Town & Country Planning Act 1990 (as amended)
Town & country Planning (Development Management Procedure) (England) Order 2015
Application for Planning Permission for Works or Extension to a Dwelling

Development Single storey front extensions (garage and porch), two storey side extension & conversion of garage into habitable space.

Location 58 Golden Avenue East Preston

client	project	drawing	date	drawn	drawing no	revision
Mr & Mrs Quaife	Extension at 58 Golden Avenue East Preston, BN16 1QX	Location + Site / Block plans	Jul 18	pd	0264 / 102	B
			scale	CAD file name:		
			1:500, 1:1250 @ A3

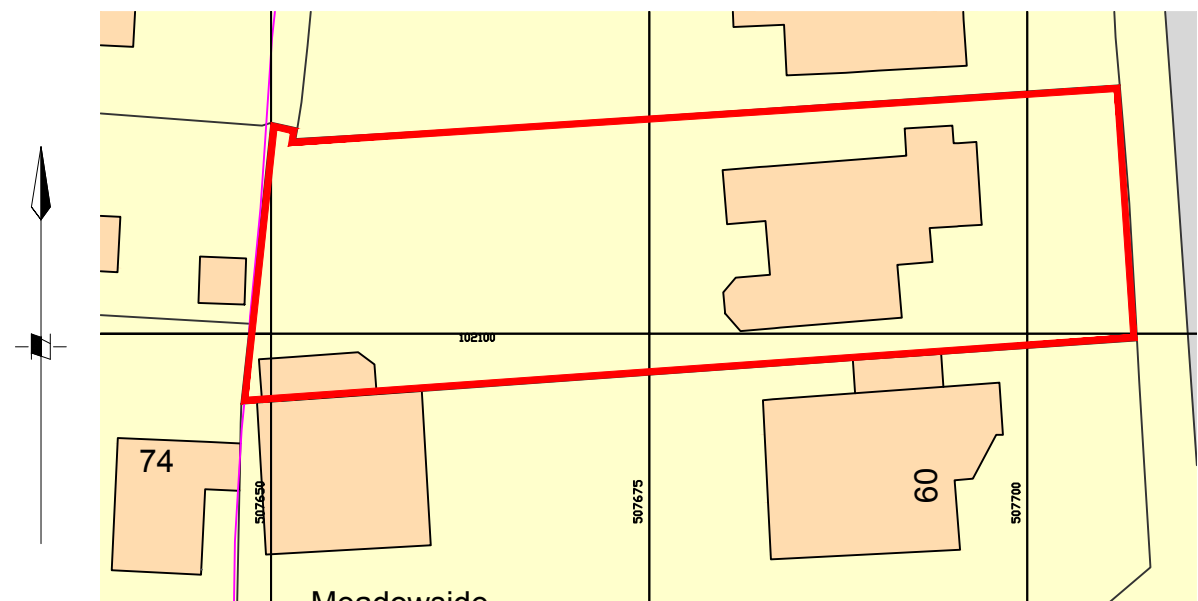
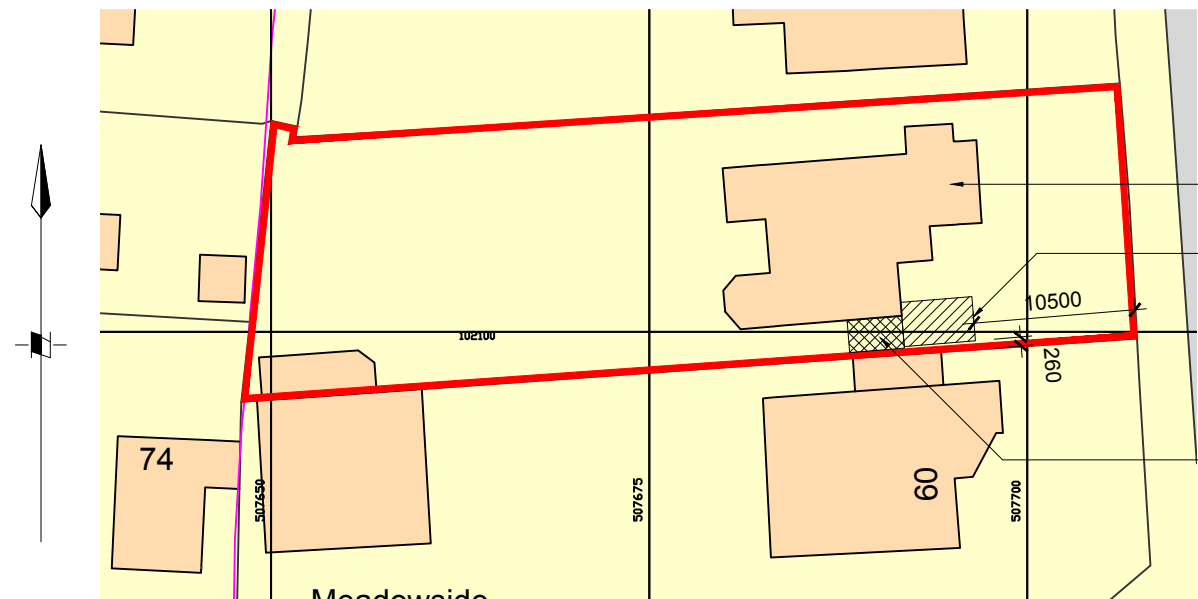
Block Plan

Please submit 1 electronic or 3 paper copies of a block/site plan at a scale of 1:500 or 1:200 showing measurements to the boundaries. Further details of what must be included on the plan can be found in the National Validation Requirements.
